DEVELOPMENT REVIEW BOARD--SPEED MEMO

DRB CASE NO/PROJECT NO: 1003675

PROJECT # 1003675

RE: Lot 1, Torres Addition; Tract C8, Town of Atrisco Grant, Airport Unit; & Lots 1, 4, Block C, Lavaland Addition

Designed: DMG	Drawn: SPS	Checked: DMG	Sheet 1 of 1
Scale: 1" = 50'	Date: 7/31/2009	Job: A09039

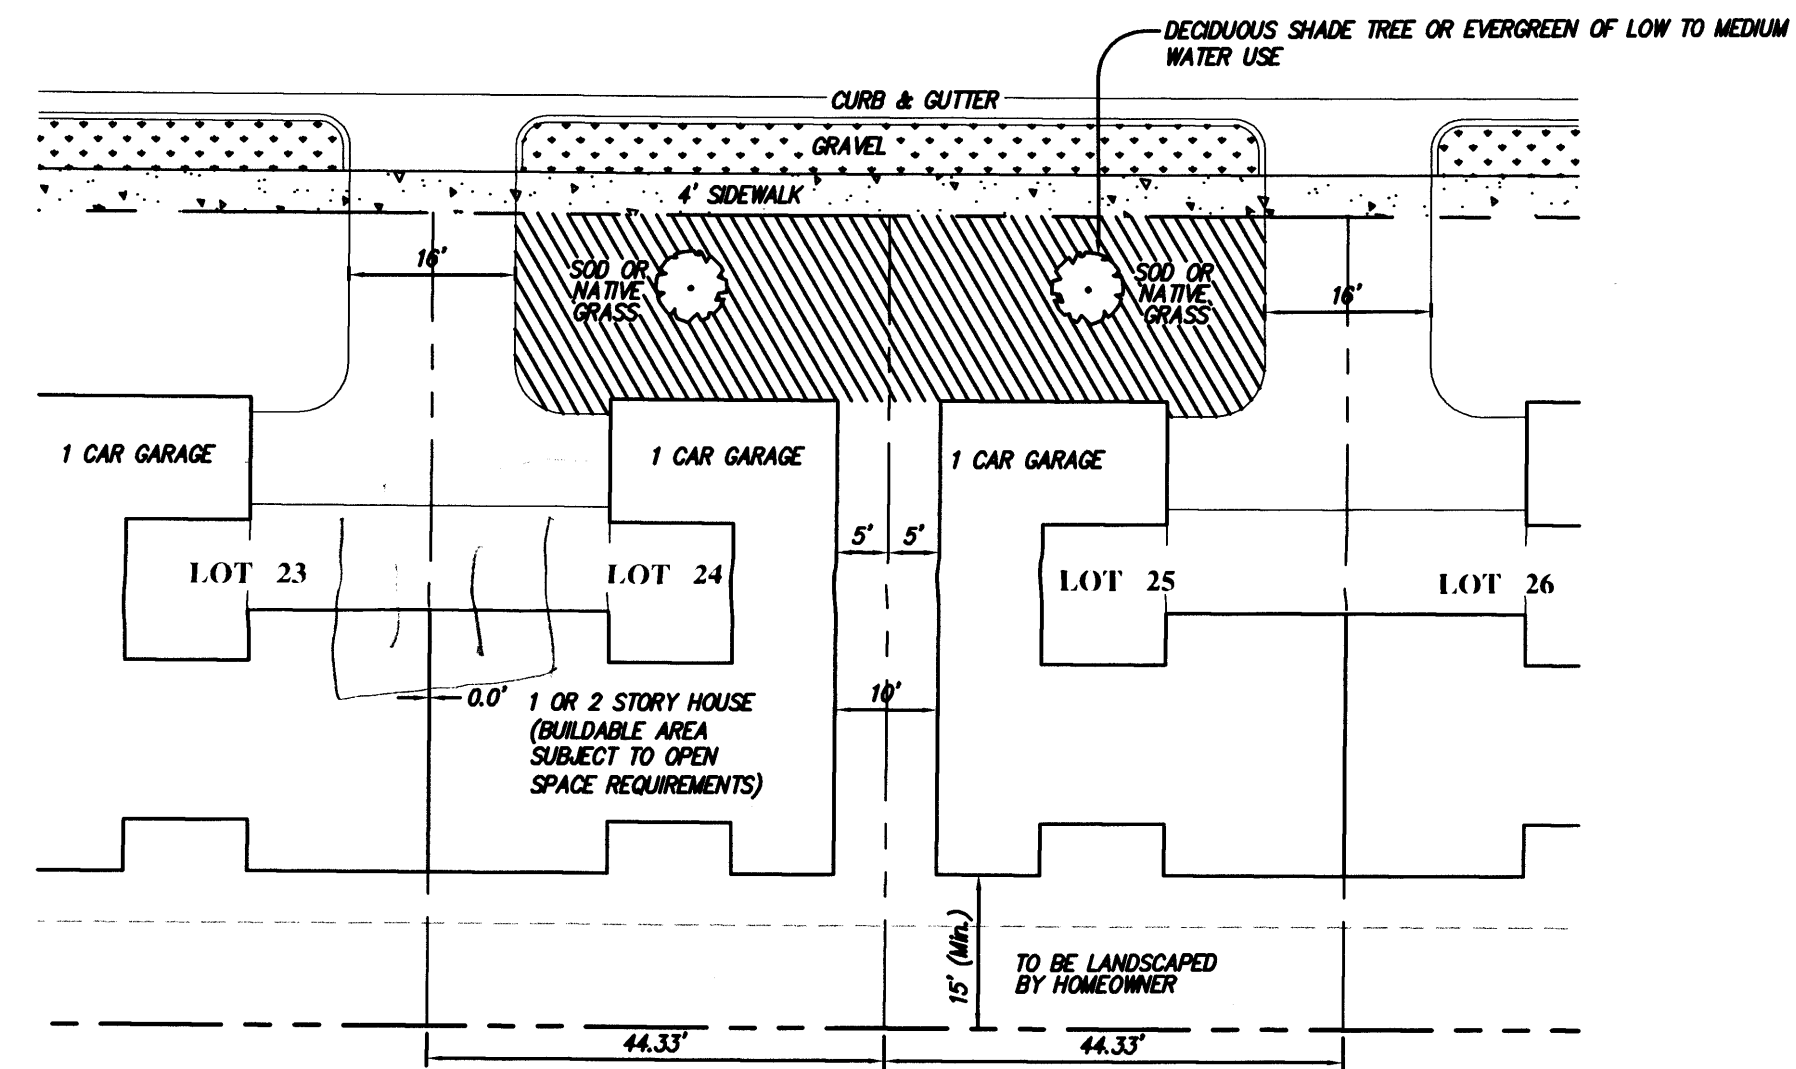
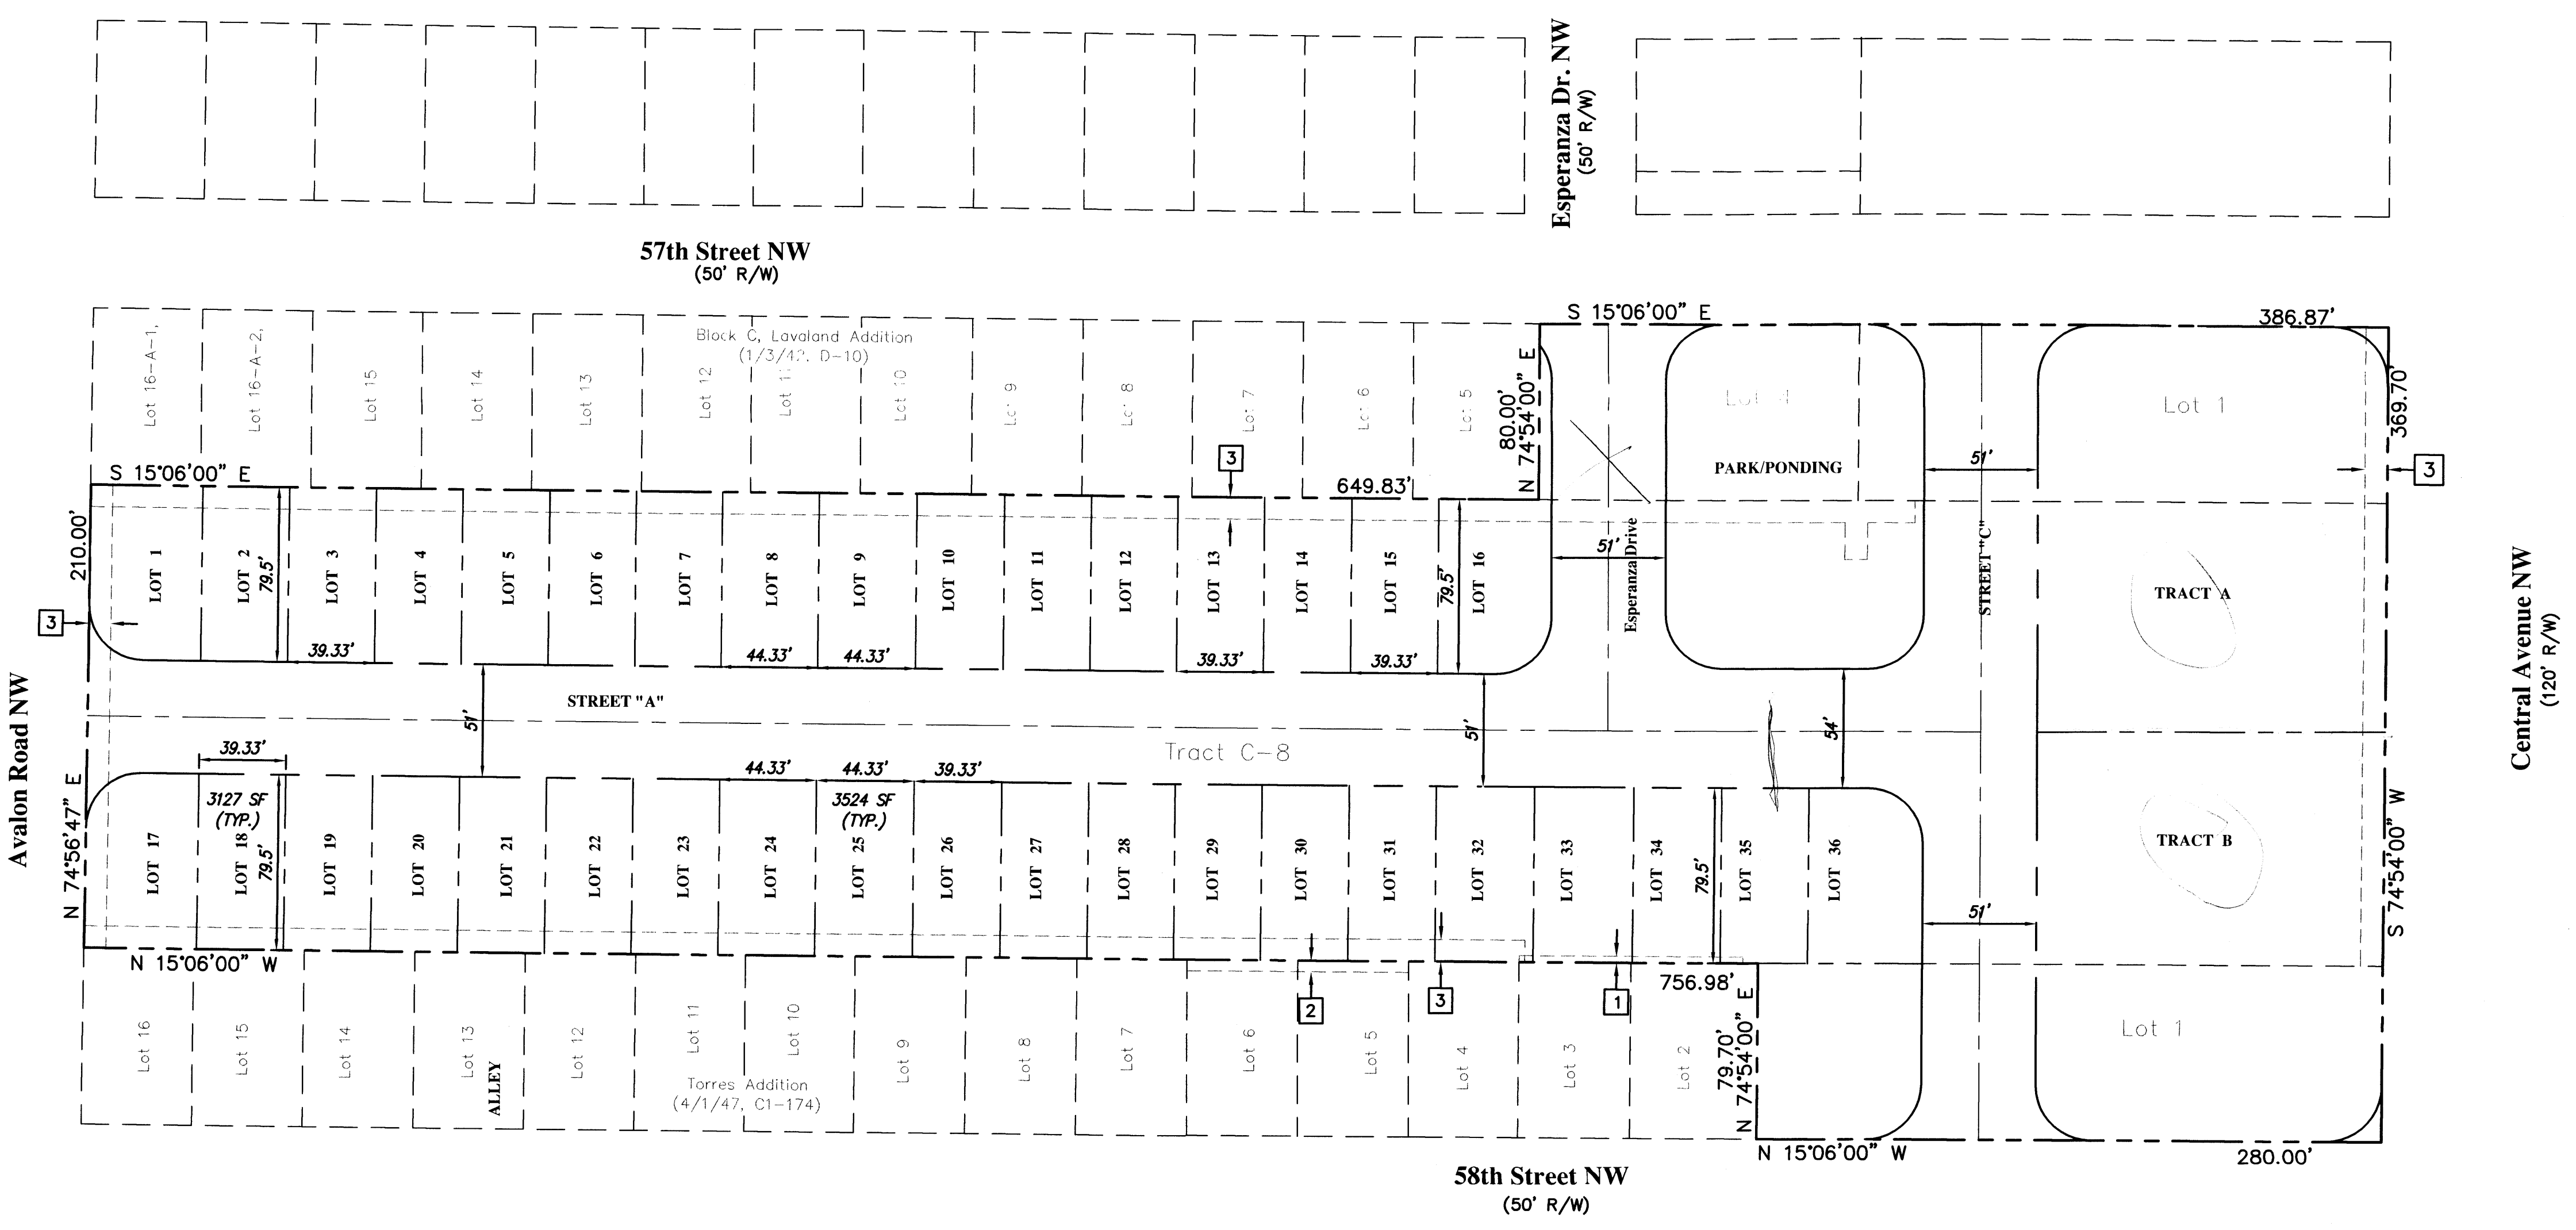
Provide an exhibit showing the location of sidewalk and defining the distance from face of curb to the property line. Right of way dedication may be required.

Geometric information (aisle widths, parking stall dimensions, all radii, slopes on ramps, etc.) must be provided prior to a complete review.

Please note that all proposed right-of-way, street geometry and roadway infrastructure must comply with the City of Albuquerque Development Process Manual and Standard Specifications. What are the lot designations and will they comply with the roadway widths?

Are the proposed streets private or public?

Please call out the distance between the existing and proposed Esperanza Drive. The proposed alignment for the extension of Esperanza Drive does not appear to meet the criteria outlined above.

The proposed residential lots do not meet the minimum requirements of the existing R-1 zoning district. Additionally, attached dwellings are not allowed, and there are incremental setback requirements for lots on a street which is aligned within 30° of north per §14-16-2-6 (E)(4)(c) of the Zoning Code. Based on 'Typical Lot Layout' a zone change to R-T would be required; however, increasing lot area to 3,200 sq ft and having maximum 3 dwellings attached would only require R-LT. Zone change requests must be justified per Resolution 270-1980 and approved by the Environmental Planning Commission. Required parking cannot count spaces aligned in tandem – a revised parking plan is needed.

Residential use is strictly regulated in the C-2 zone; a zone change would also be needed for proposed Lots 35 and 36. Further, the C-2 portion of this site is within the West Route 66 Sector Development Plan area and would be subject to those regulations.

Extension of Esperanza Drive appears unneeded given proposed Street "C." Regardless, a Subdivision Design Variance would need to be requested for block length greater than 600 feet.
